SUBJECT: Engineering Review Comment
Mountain View Electric Association Inc. (MVEA)

Project Name: Urban Landing Filing 1 – Final Plat

Project Number: SF252

Description: Proposed development of 49 residential lots and 4 tracts located at the southeast corner of Spanish Bit Dr. and Struthers Rd. in Township 11S, Range 67W, Section 36.

SHEET 1 OF 2  
JANUARY 8, 2025  
JOB NO. 1308.00  
URBAN LANDING FILING NO. 1

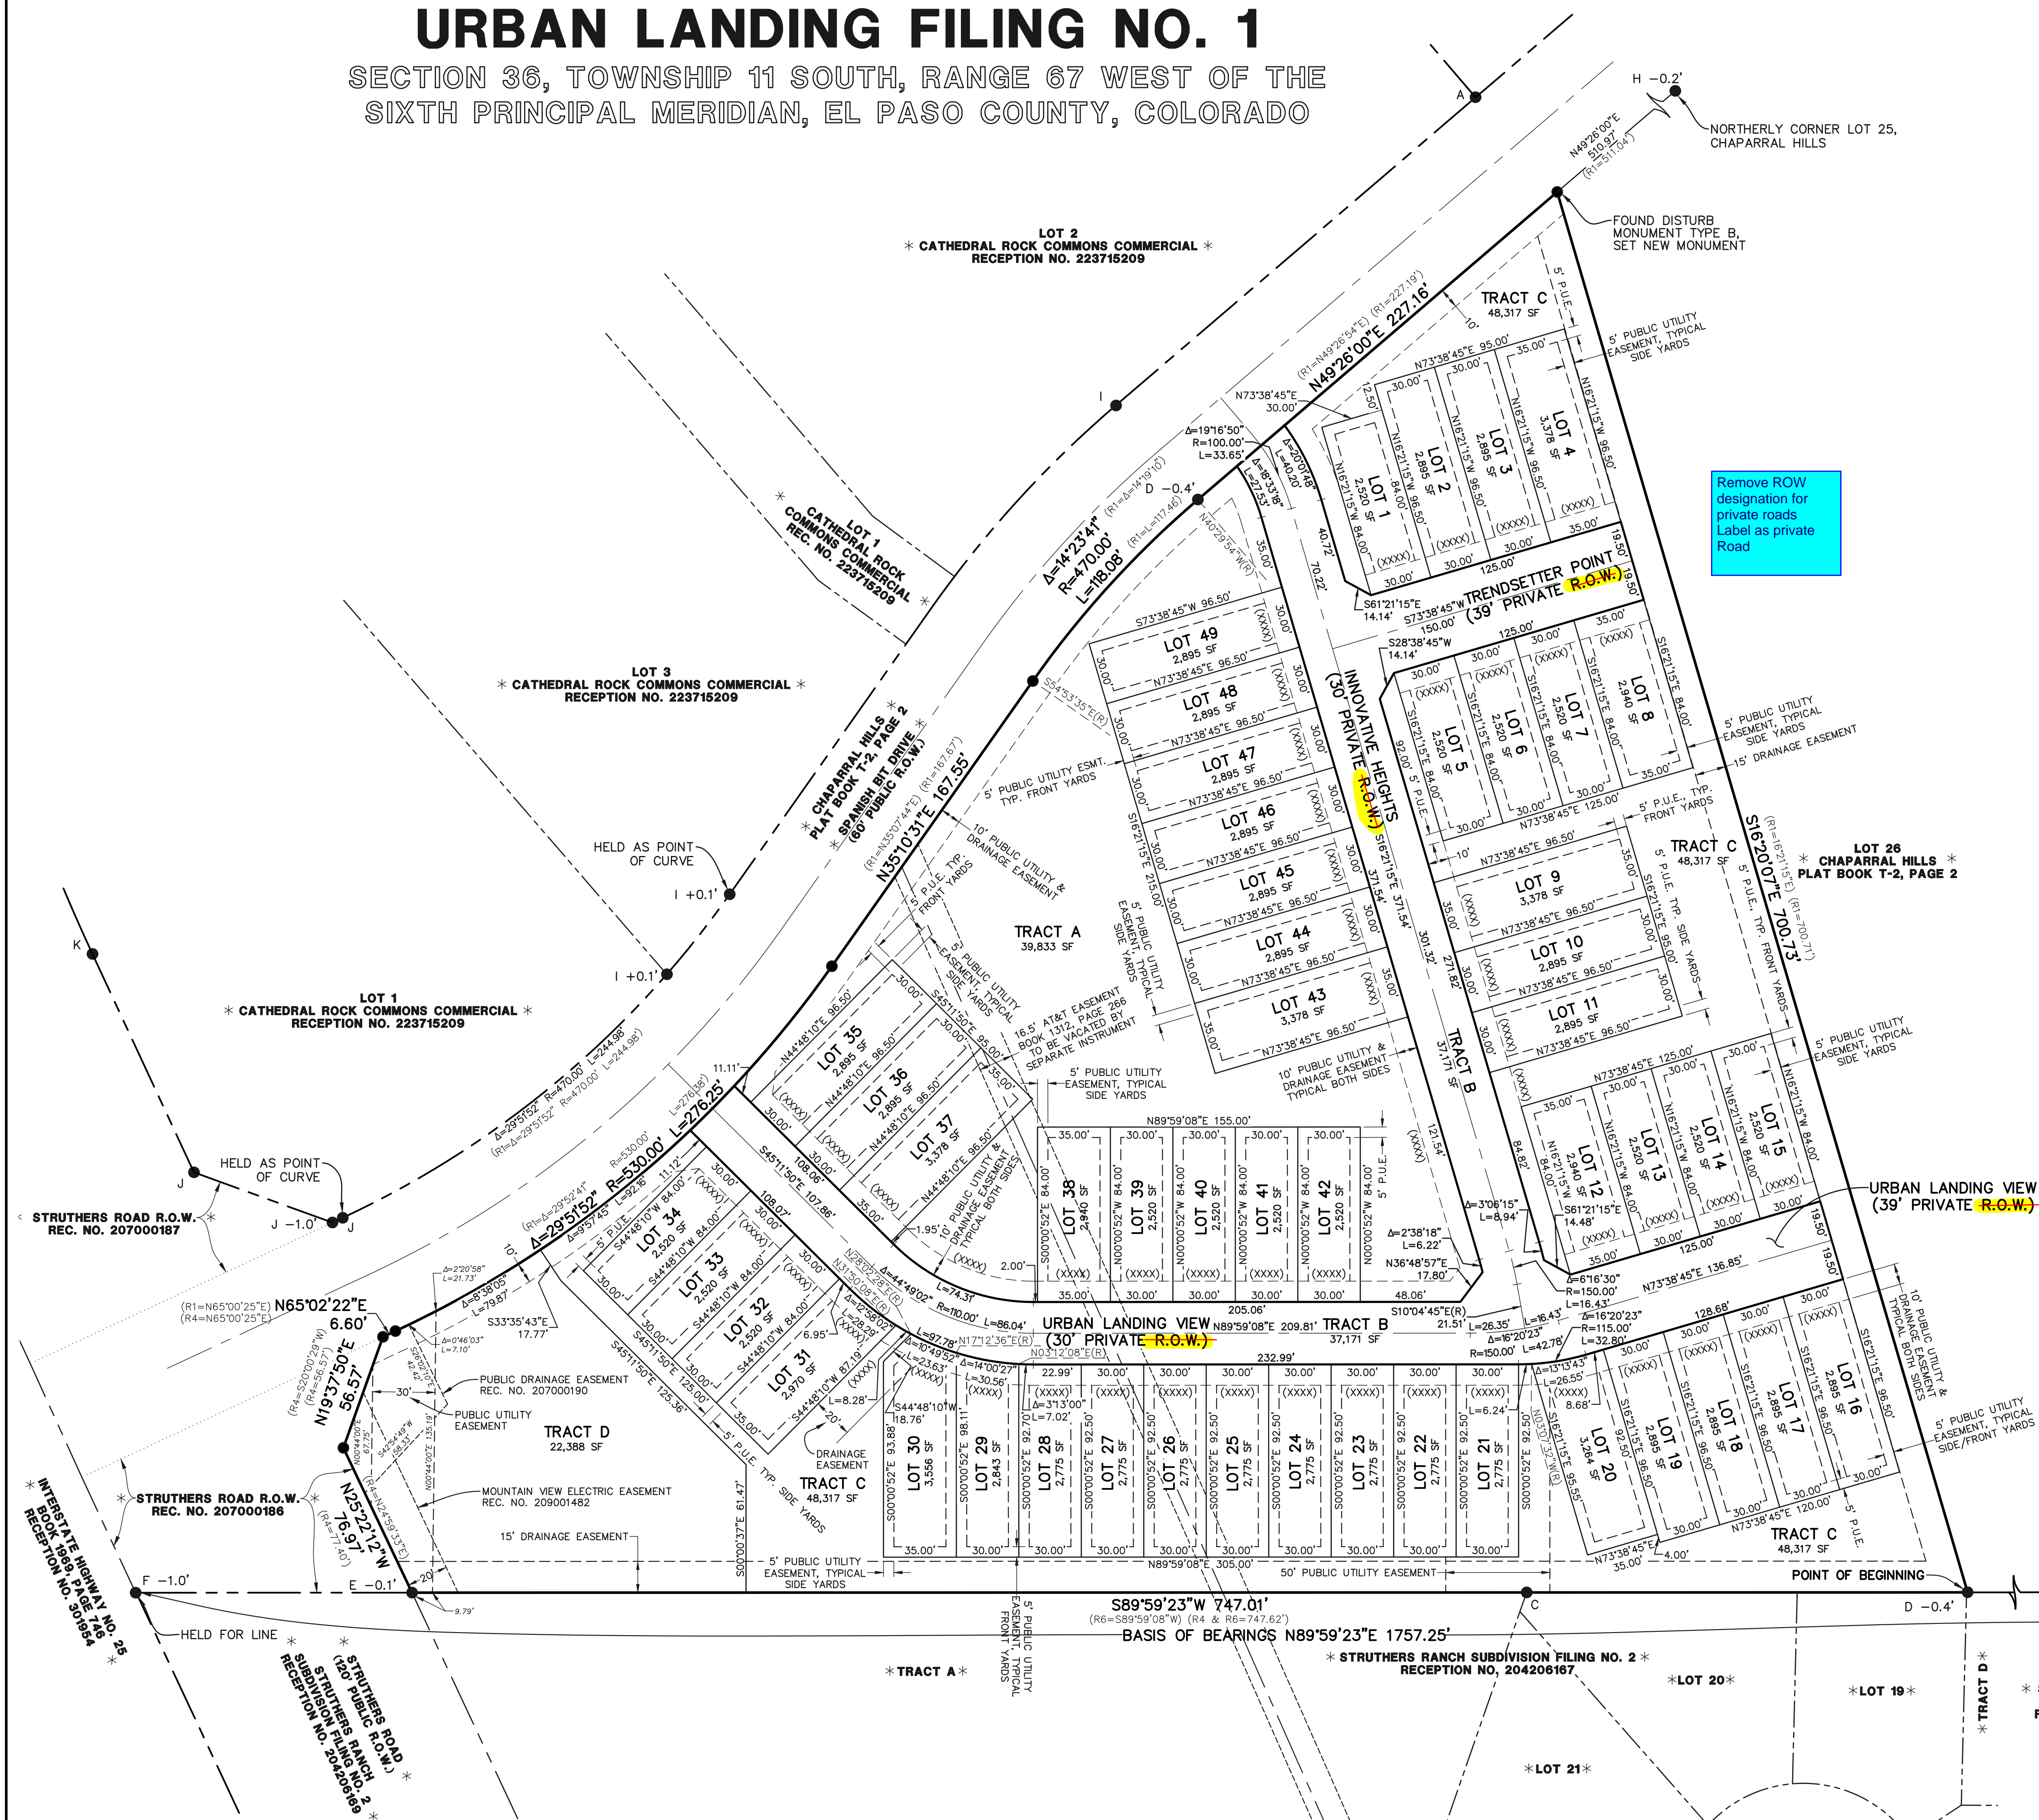
MVEA requests a ten (10) foot front lot utility easement, in addition to any public improvement easement, a five (5) foot side lot utility easement, and a seven (7) foot rear lot utility easement along with a twenty (20) foot exterior utility easement on the plat and all tracts include easements. MVEA also requests the platting of MVEA's existing facilities with easements on the plat. Additional easements may be required.
